From: Martyn White <Martyn.White@arun.gov.uk>
Sent: 13 August 2021 14:46
To: Planning.Responses <Planning.Responses@arun.gov.uk>
Cc: Anita Gardner <Anita.Gardner@arun.gov.uk>
Subject: LU/212/21/PL

LU/212/21/PL

3-4 Selborne Place Selborne Road Littlehampton BN17 5NH

Change of use from A3 Restaurant / A4 Drinking Establishment to C3 Dwelling Houses (5 No. 1-bed flats & 1 No. 2-bed flat). This application may affect the setting of a listed building

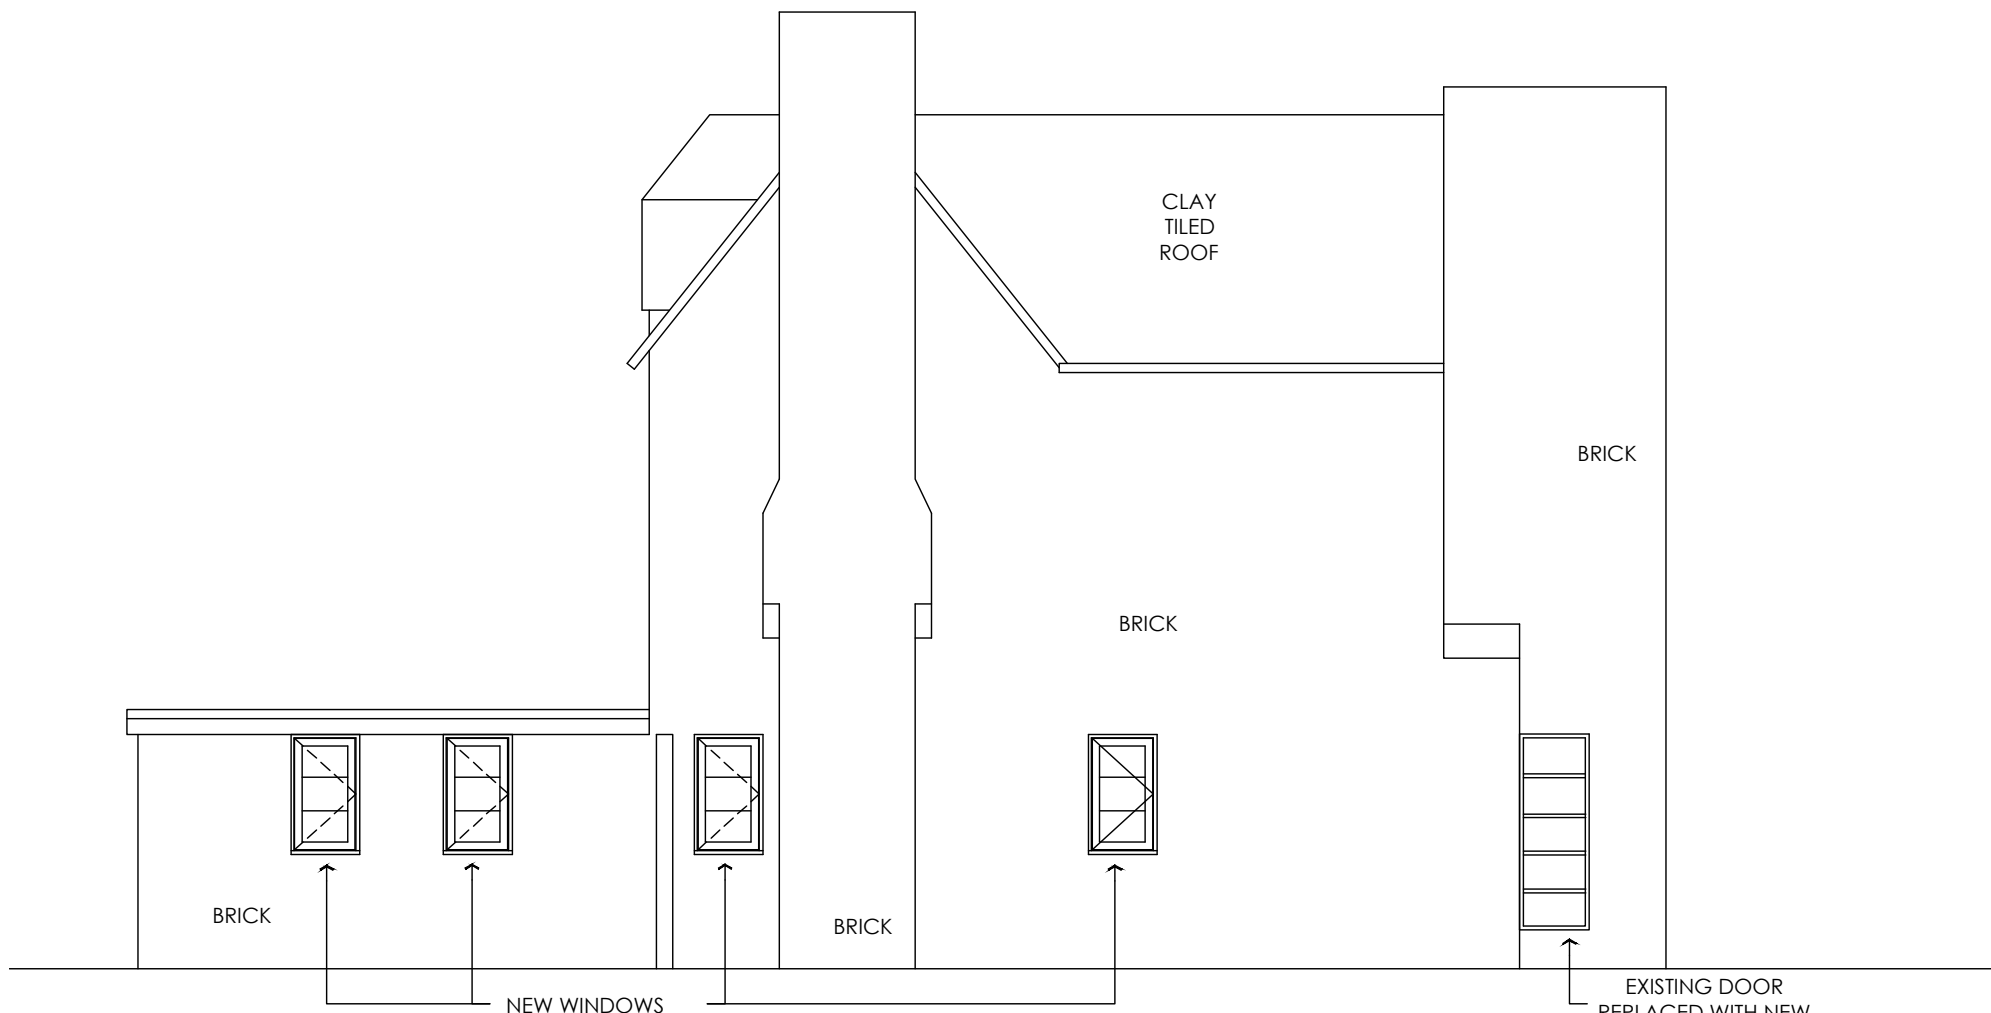
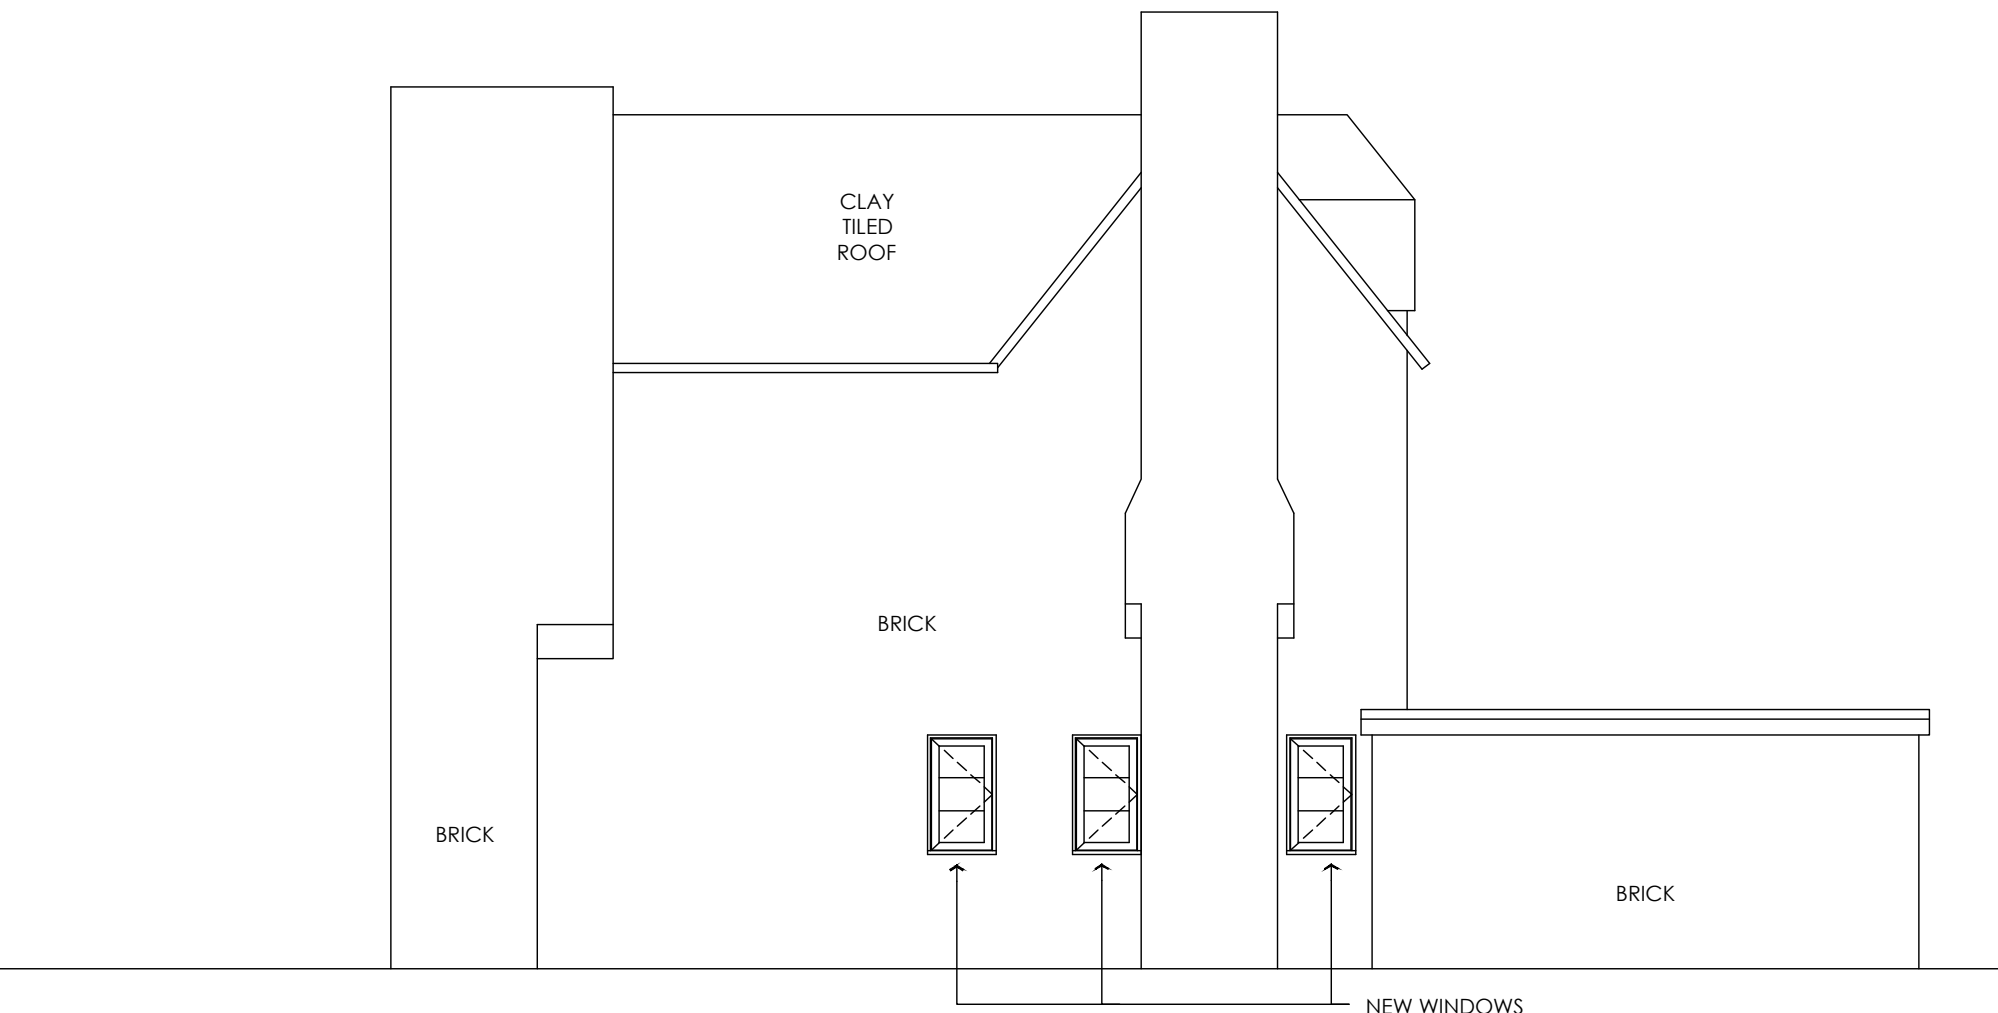
Externally, it is positive to note that the existing UPVC façade to the southern elevation will be removed and a new brick wall will be provided, with new white painted timber windows. The existing rear elevation is harmful in terms of appearance and materials used, and it is good to note that the applicants wish to enhance this part of the building. I would, however, want to make sure that wooden windows are used as proposed. Further, I would want to ensure that both the brick and brick bond to be used is appropriate. Details of both could be provided for by way of condition, if you are minded to approve the application.

It is also clear that the intention is for two doorways on the northern elevation to be replaced with new timber windows formed within the arched openings. It would be positive if the doors could also be kept in the openings and be designed so that they could be fixed open with a modern window behind. This will allow for the window to be covered and the original elevation restored. This would read as if the doors had been left open. If this approach is acceptable, details of the opening/window and door would be required by way of condition.

A number of new windows are also proposed in the eastern and western elevations which will also be formed in timber, painted white. This is acceptable subject to their design.

If minded to approve the application I suggest that details of the new windows and doors as well as details of their positioning within the new/existing openings be provided. This is to ensure that they reflect the age and character of the building and are installed away from the brick face to help create an appropriate shadow line.

A number of new glazed lanterns will be provided within the existing flat roof to the current single storey structure on the southern elevation.

- If minded to approve the application, I would like to see details, detailed plans and sections of the proposed windows and doors at an appropriate scale. The submitted details shall include the style and material of the window frames, the arrangement of glazing bars, the set-back of the frames from the external wall face and the window sills, together with details of proposed finishes.
- Details of the proposed bricks to be used
- Before development commences, details of the brick bond to be used on the new brick work shall be submitted to and agreed by the LPA

Proposed Ground Floor Layout Plan

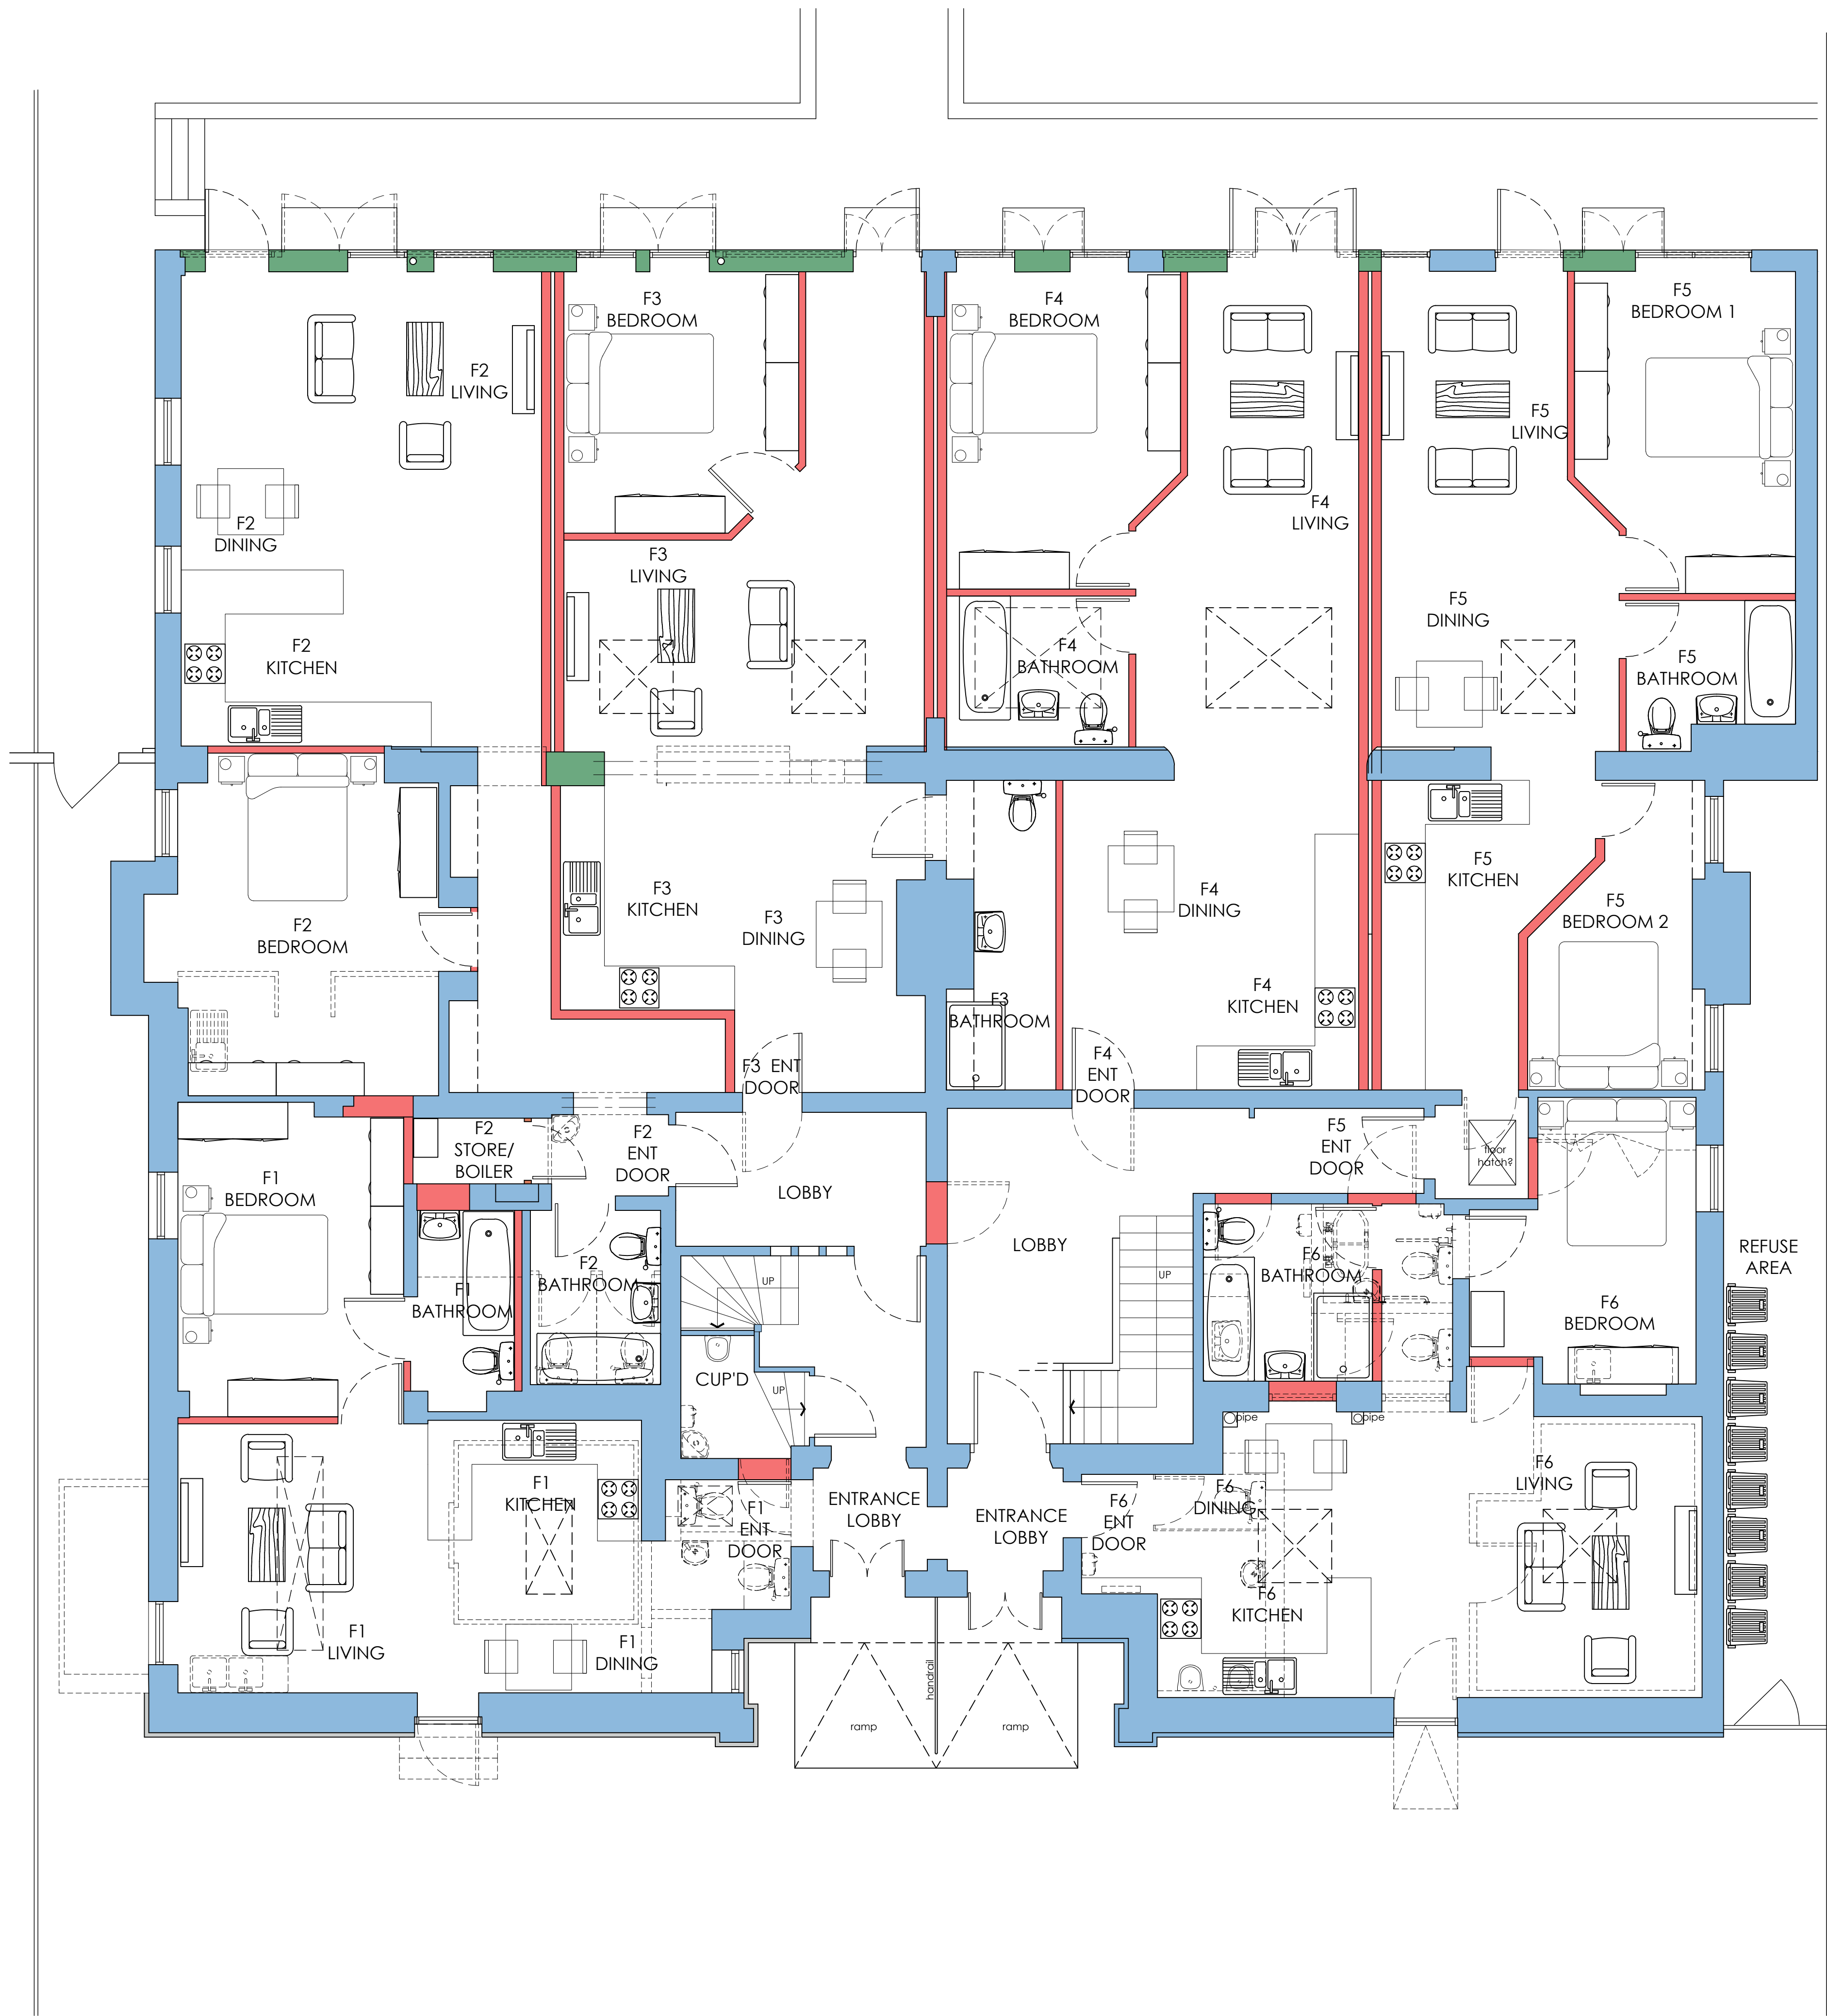
Whilst a number of alterations have already been made to the ground floor of the building, it would appear that a large number of flats would be installed into what was originally the ground floor space to two homes and their associated extensions. This is unfortunate. However, the proposed use itself is not problematic as both the building was originally residential, and the conservation area itself is more residential than not.
